April 4, 2023  
File No. 19-062.200

**Subject: Geotechnical Plan Review, Report Addendum, Comment Response  
Proposed SFR, East Lot, Parcel 302405-9151  
6423 E Mercer Way, Mercer Island, WA**

Sheet Number
S3.0
6 of 10

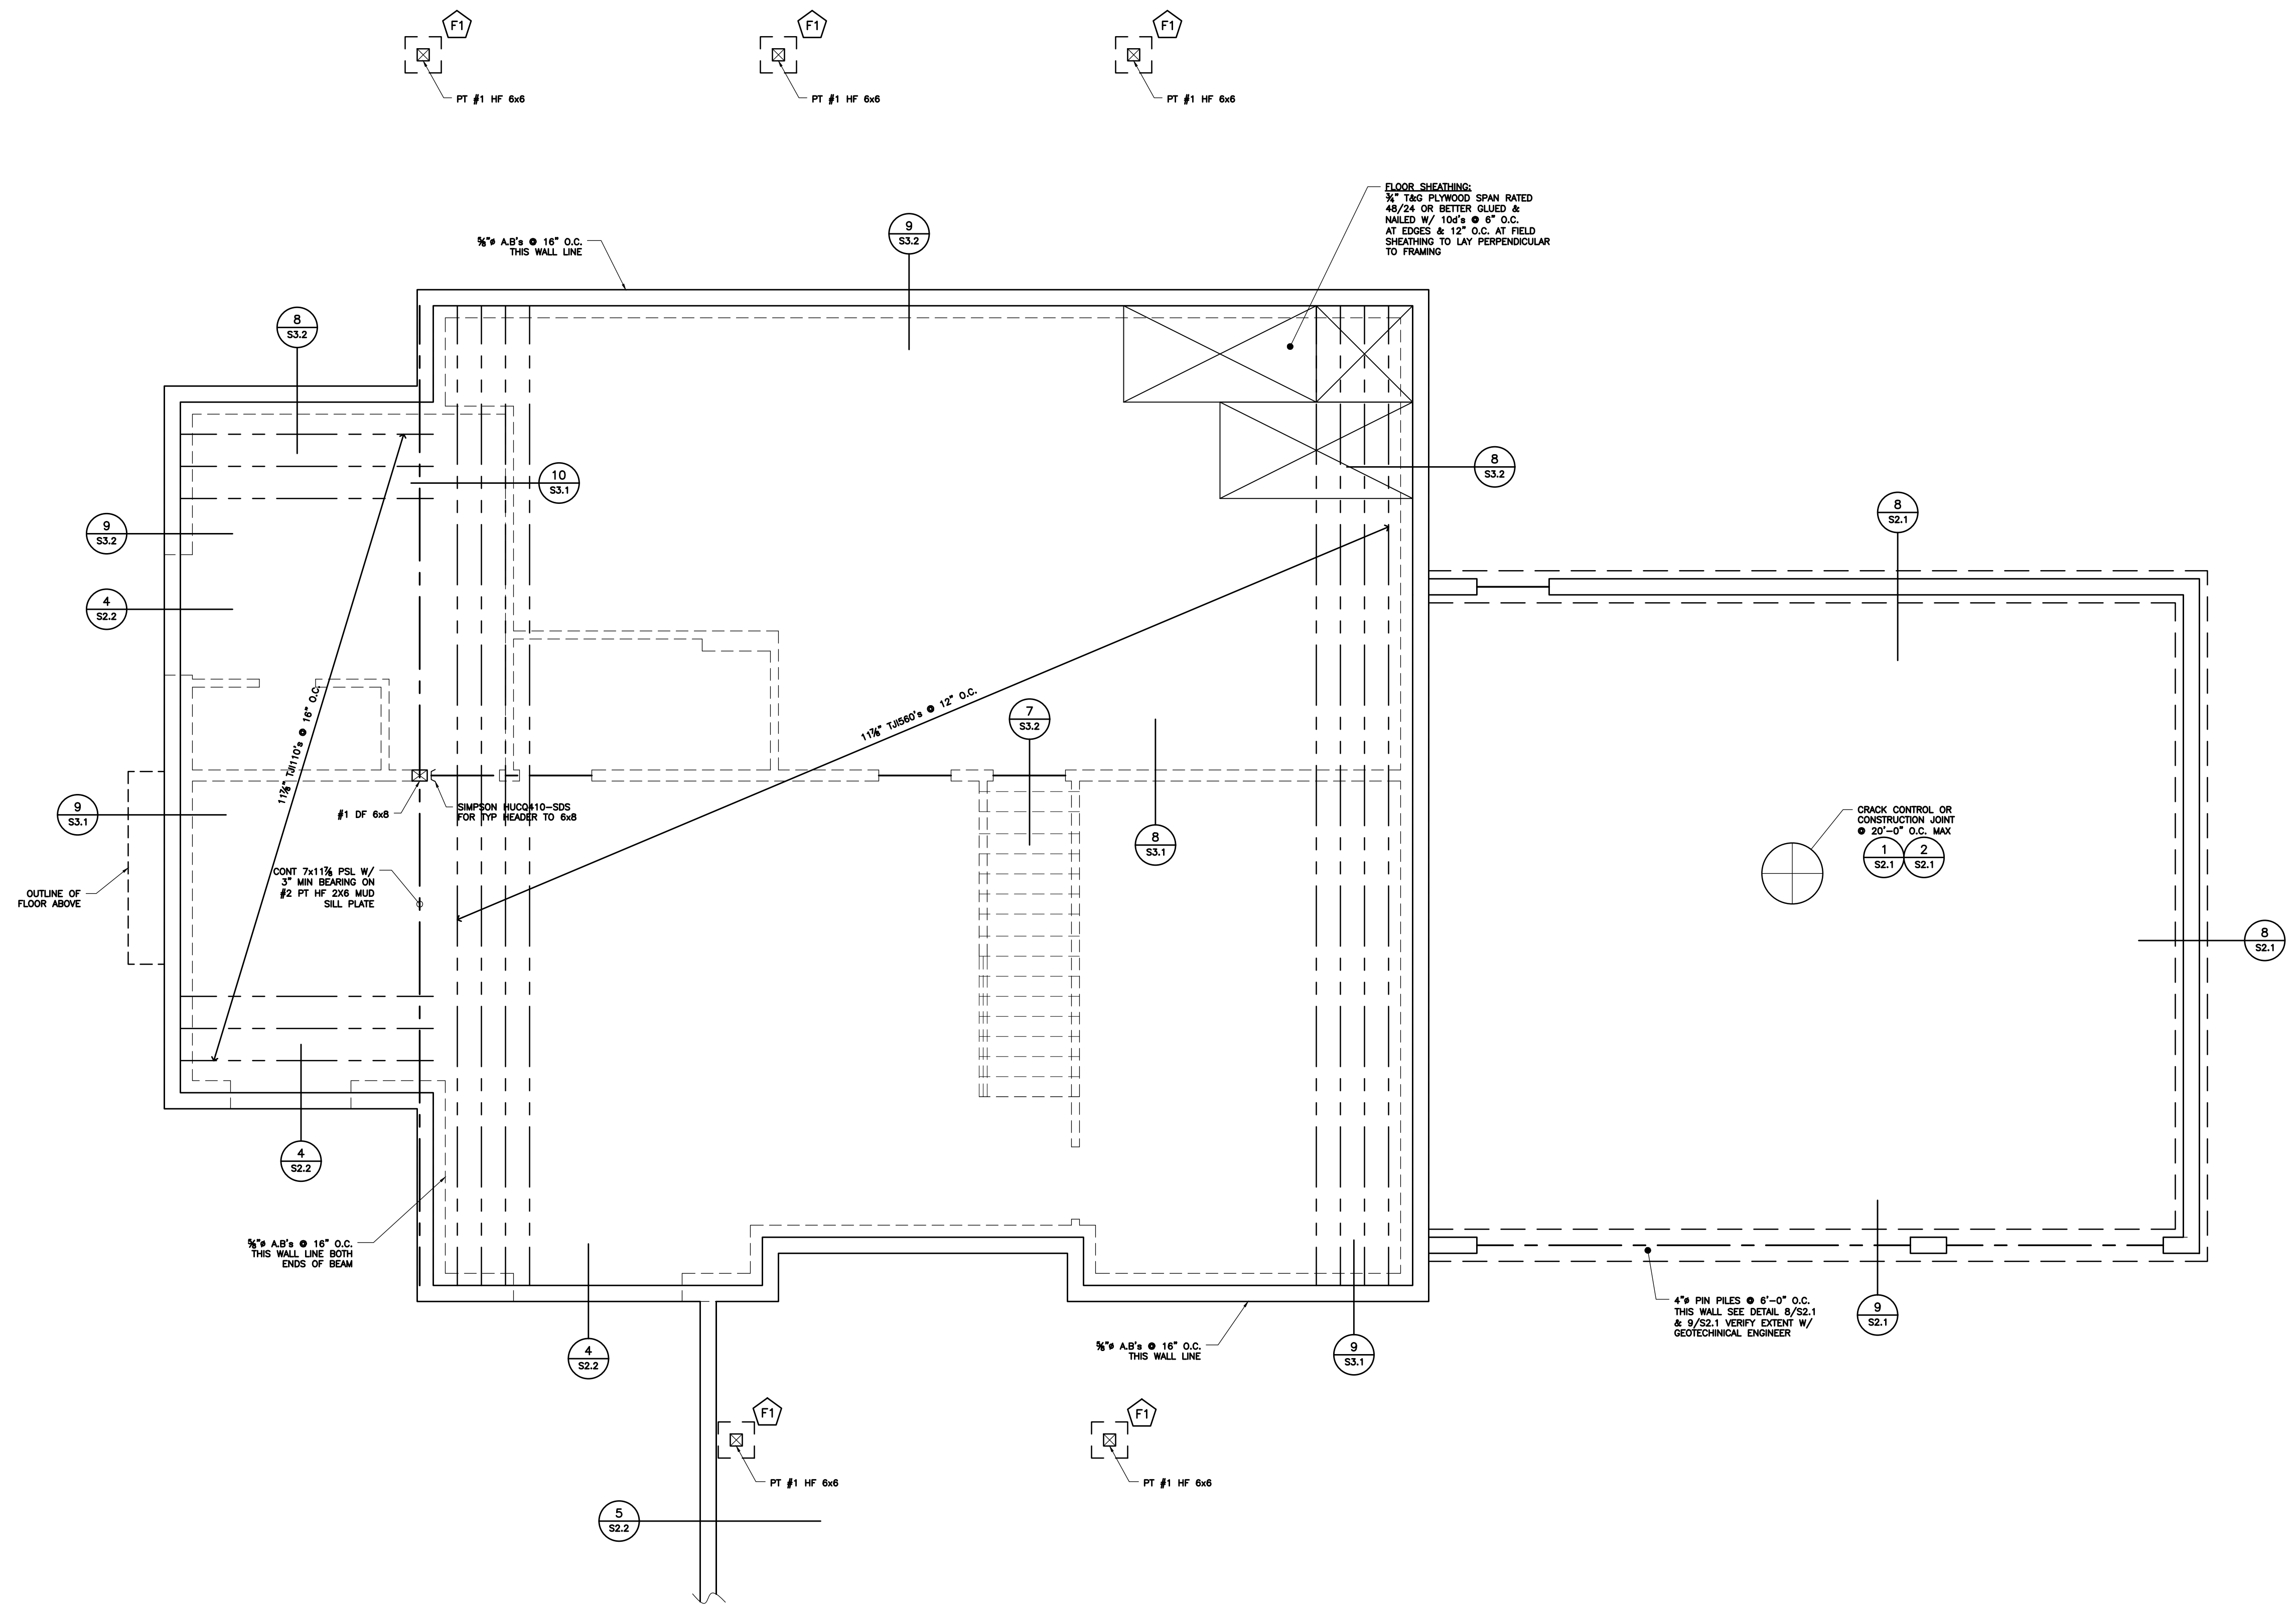
- **Entry Column Footing Support** – The two columns on the north side of the house at the entry are underlain by 8 to 10 feet of loose fill or alluvium. Consequently, we recommend supporting the columns on 2” diameter pin piles. 2-inch pin piles driven to a refusal criteria of one inch of penetration over one minute of continuous driving, using an 80-lb jack hammer or 140-lb Rhino hammer, will support a load of 3 tons. As stated above, welded couplers are not acceptable. Pipe sections should be joined with compression sleeve couplers.

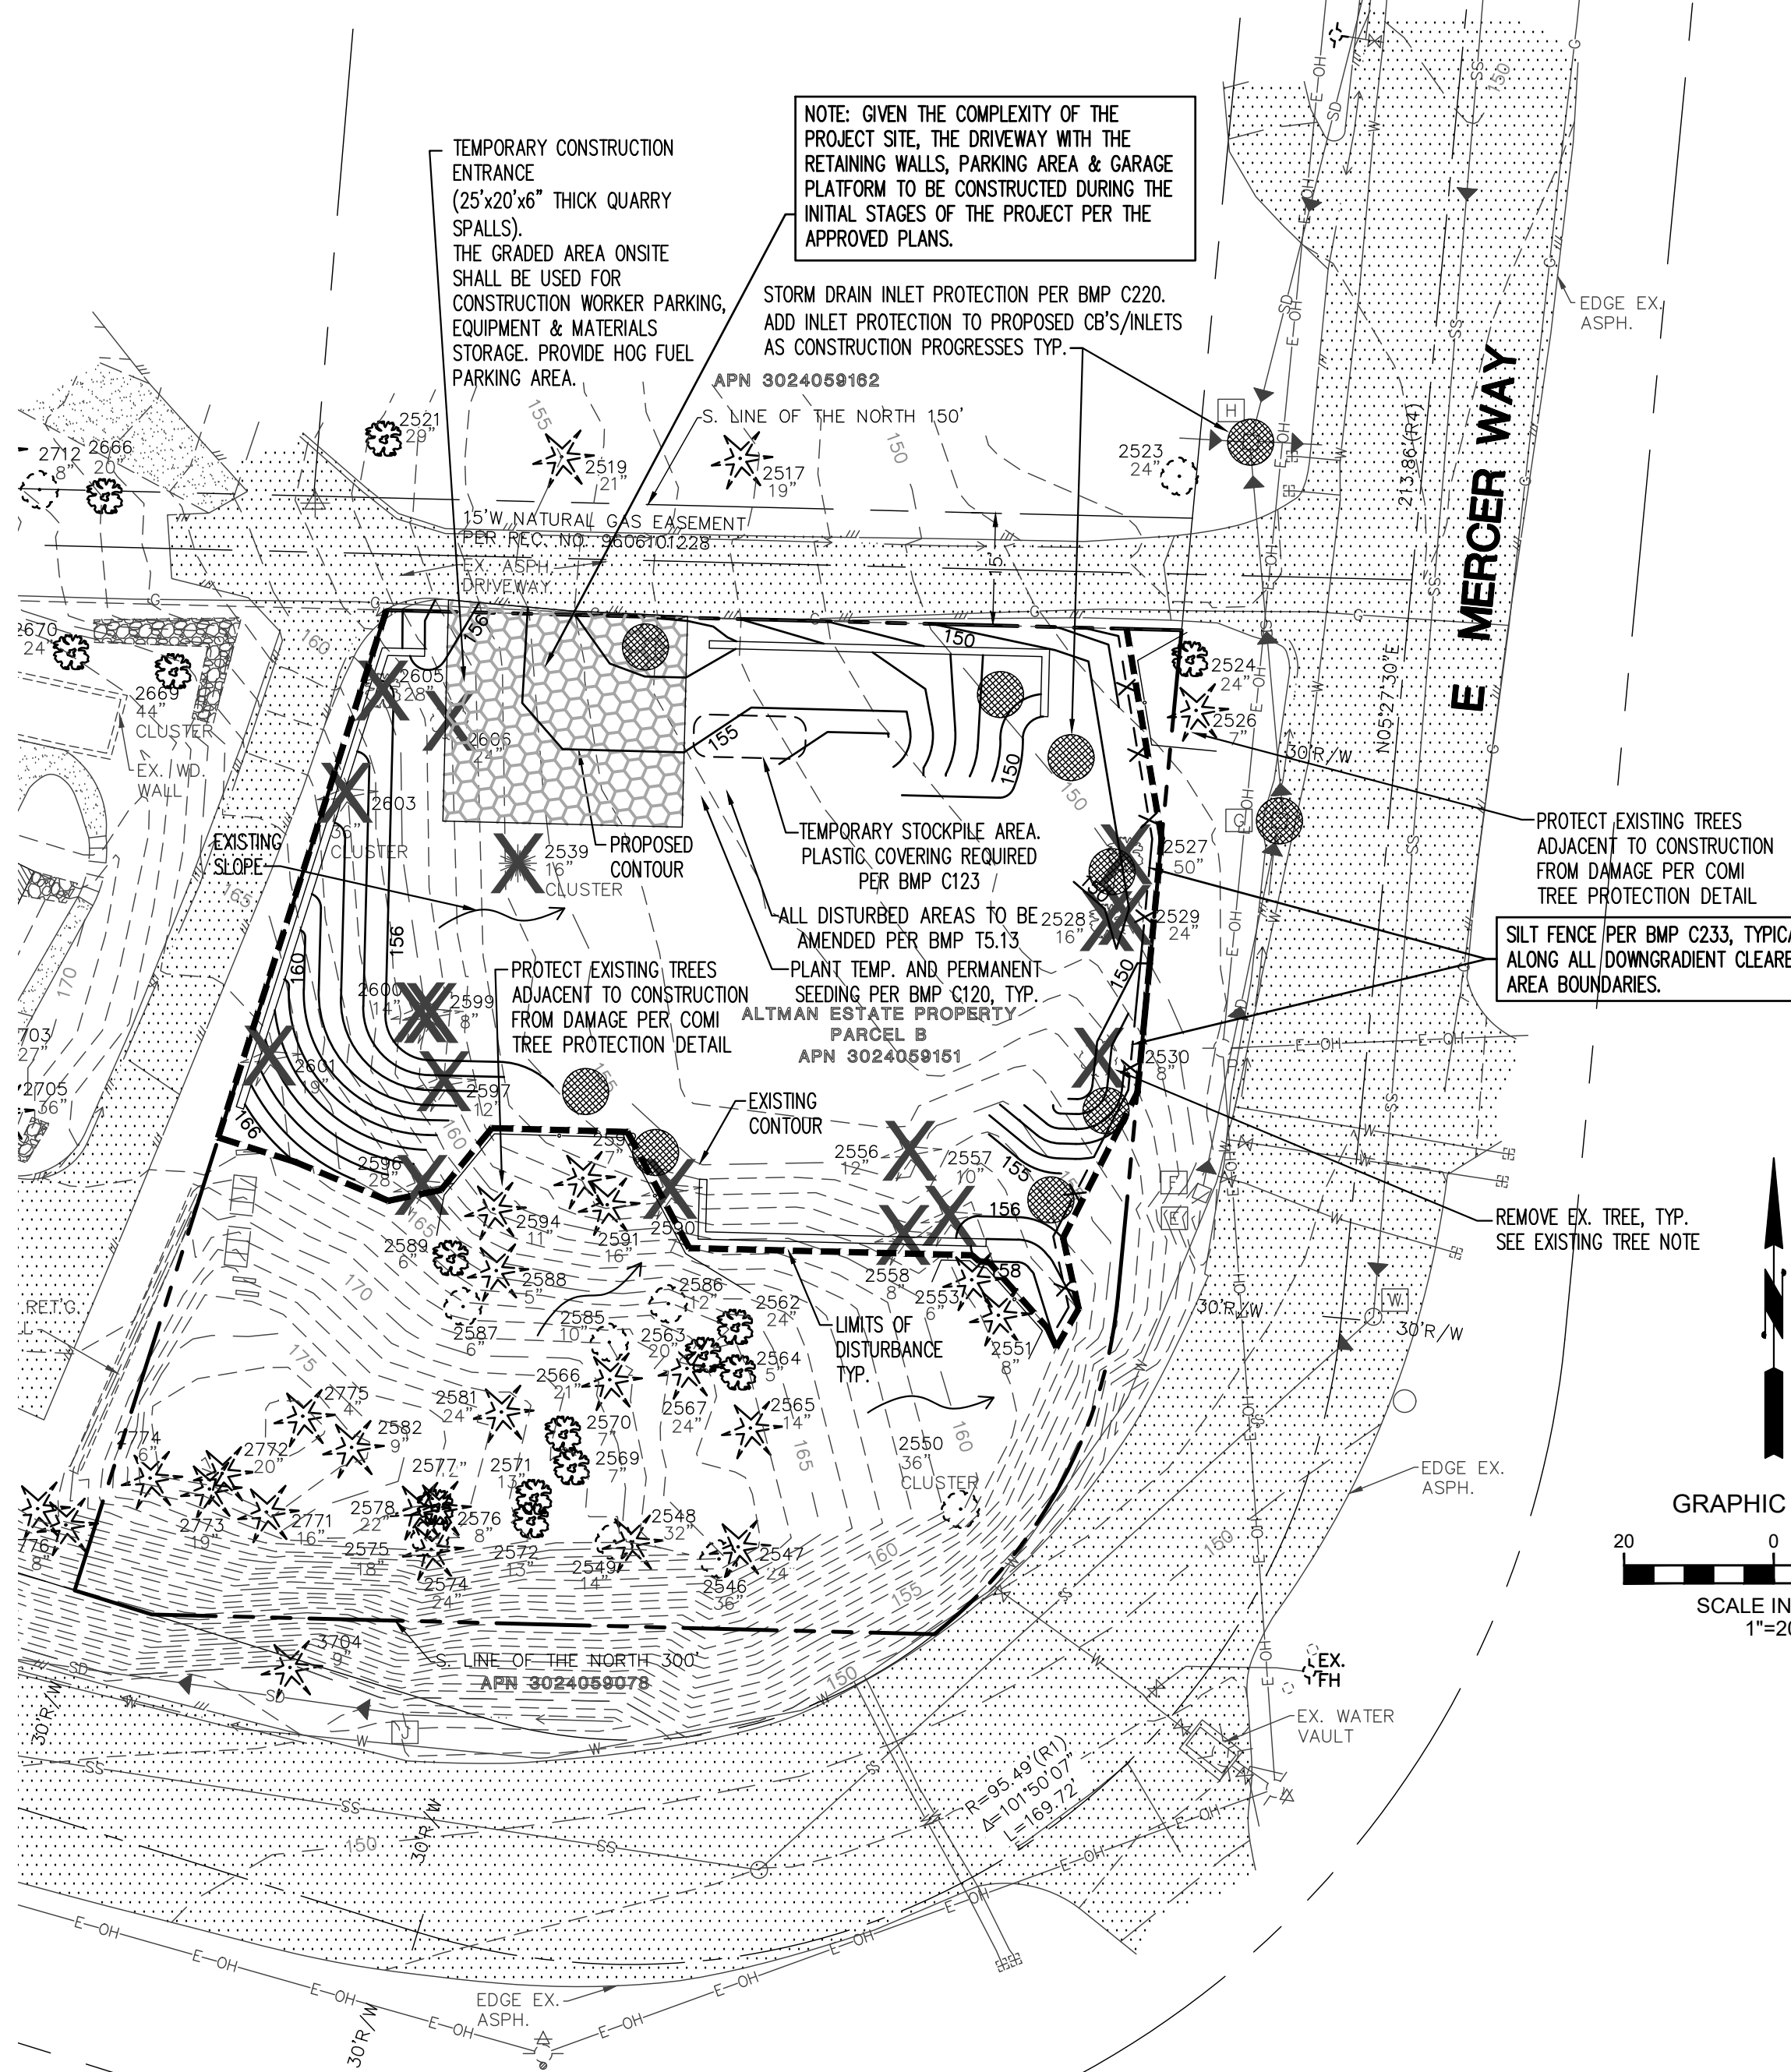
- **Sheet 2 of 5** – Purely a comment for the Civil Engineer.
- **Sheet 3 of 5** – Five comments mainly for the structural engineer. As stated above, we recommend using a revised coefficient of friction of 0.3 and a passive resistance of 300 pcf for all structural calculations. An easement will be required for construction of a retaining wall along west property line unless there is space available for an open 1H:1V cut slope. Vertical cuts greater than 4 feet are not acceptable.

- Open cuts in glacial soils should be sloped 1H:1V. Loose alluvial soil may require slopes of 2H:1V. Trench boxes may be used for temporary shoring in lieu of open cuts. The final comment regarding the back slope above the retaining wall south of the house will have to be addressed in the final grading plan.
